Subject: FW: BR/267/21/PL Former Westside Supplies Unit, Durban Road, Bognor Regis

Figure 3.1: Habitats present on the site. See main text for target note descriptions

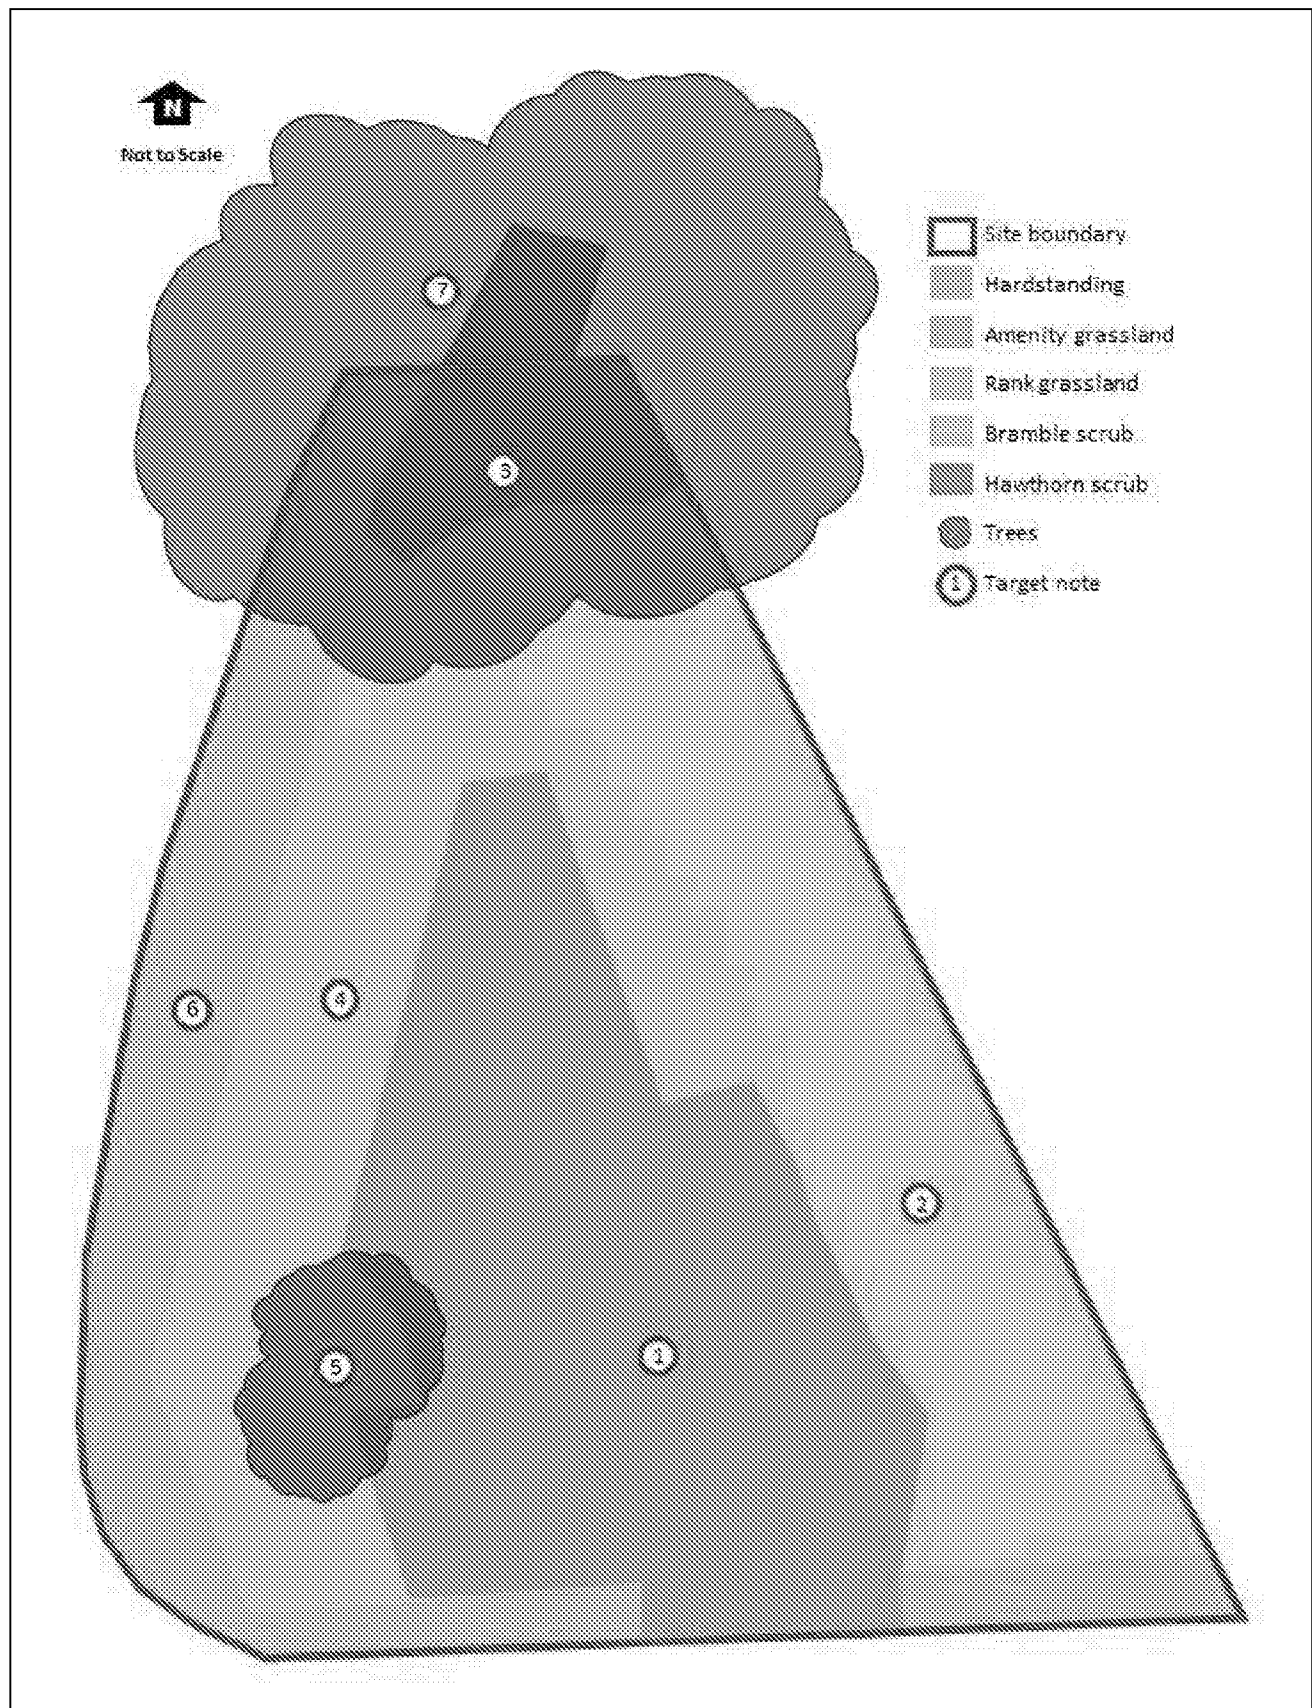
Your comments on this application requested that the three mature Willows trees be retained & safeguarded as mature willows are regarded as being some of the most likely for having bat roosting features.

However, the implementation of the proposal relies on felling the two Willows within the site and pruning the third (which is off-site). Their Ecological Appraisal states at 3.4.2 that *"no suitable roost features were noted on the large willow trees at the northern end of the site, although these were not surveyed in detail. The site may be used by foraging bats, although it is too small to be of significant value."*

Clearly this puts us in an impasse. Although the trees are not worthy of preservation so assuming no bat roosts present, they could be felled/pruned. I have requested a response from their ecologists in relation to your point. This is being reviewed but the agent has come back to me to ask if you would concur that the site is too small to be of significant value.

I note that the submitted Ecological Appraisal states at 3.4.2 that *"There are no buildings or trees on the site that are suitable for bats to roost. No suitable roost features were noted on the large willow trees at the northern end of the site, although these were not surveyed in detail. The site may be used by foraging bats, although it is too small to be of significant value."*

However, conversely our ecologist has stated that *"the three mature white willows much be retained as part of this application and safeguarded as per the appropriate British Standards. Mature willows are regarded as being some of the most likely for having bat roosting features"*

I note that the scheme is dependent on the removal of two trees/pruning of the third so any permission would need to sanction their loss and instead seek appropriate biodiversity net gain to compensate for the loss. However, can you get a response from your ecologists to our ecology comment. It would also be helpful if the trees could be surveyed in detail. I look forward to hearing from you.

What the ecologist did say was that the council's view differed from theirs (as you noted also) and their view is still *'The site may be used by foraging bats, although it is too small to be of significant value...'*

This makes me wonder whether we need opinions to align first? Perhaps if we can all agree it is too small to be of significant value then is this an issue?
